C.RO Ports Killingholme Limited

The Able Marine Energy Park Development Consent Order

Planning Inspectorate Reference: TR030001

Written summary of the oral representations of C.RO Ports Killingholme Limited at the Issue Specific Hearing on the draft Development Consent Order including Deemed Marine Licence, 21 and 22 November 2012

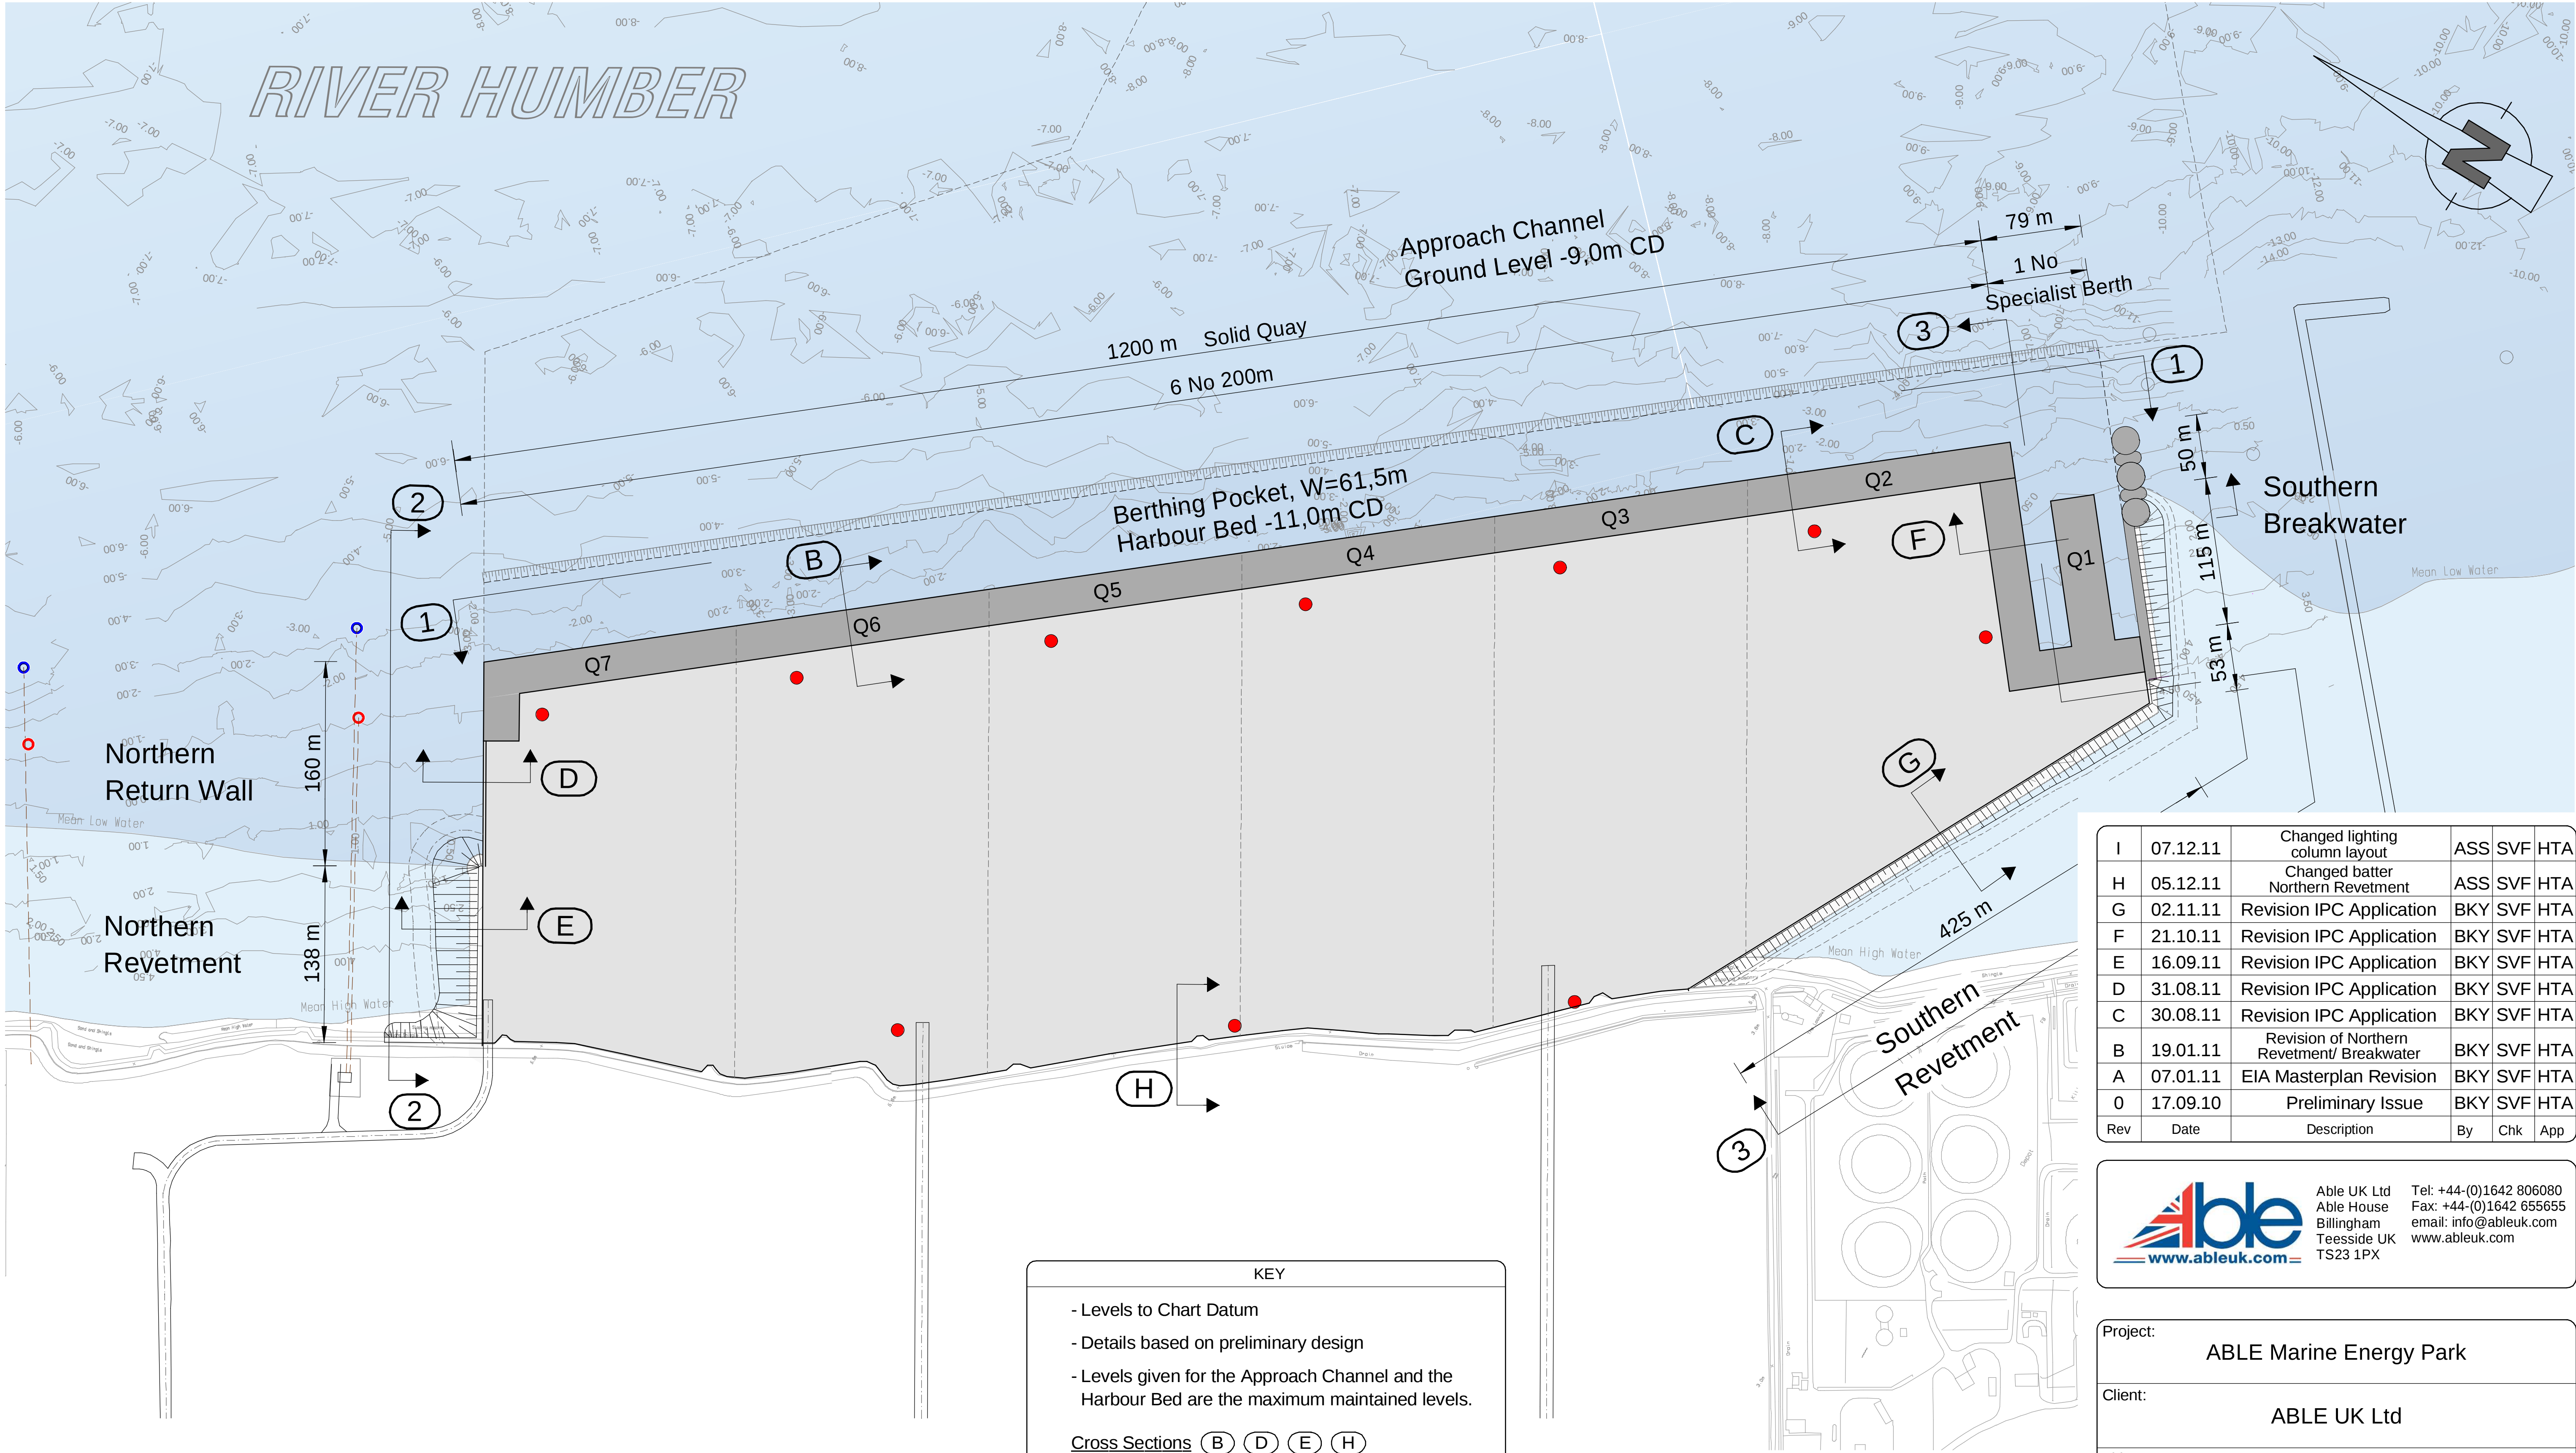
1.7 When the coordinates provided by Able for the berthing pocket are reviewed it appears that the shape of the berthing pocket has been amended. The berthing pocket now appears to extend around the upstream end of the quay face. This gives rise to concerns as to the validity of the modelling that was submitted as part of the application, and the further modelling information submitted during the course of the examination.

1.8 Both the original and further hydrodynamic modelling work has been for a berthing pocket at a dredged depth of -11mCD, terminating level with the upstream end of the quay. The reason for extending and deepening the berth pocket around this end of the quay has not been

explained by Able. EX 8.7A, which was provided as further information and dated October 2012, shows the berthing pocket as finishing level with the northern end of the quay. It is not understood whether Able has now amended the shape of the berthing pocket, or if the coordinates that were provided at the ISH are incorrect.

- 1.9 In any event, the berthing pocket coordinates that have been submitted to the examination as the final coordinates do not reflect the application design, or any of the hydrodynamic modelling data. If these coordinates are the most up to date indication of the location of the berthing pocket then the validity of the hydrodynamic modelling data submitted by Able can be questioned. This is particularly in relation to conclusions that have been drawn in respect of tidal flow, rate of flow, recirculation and sedimentation transport within the main column of the tidal flow and that of the intertidal. There also may be a change in the present recirculation patterns around the Centrica and E.ON outfalls.
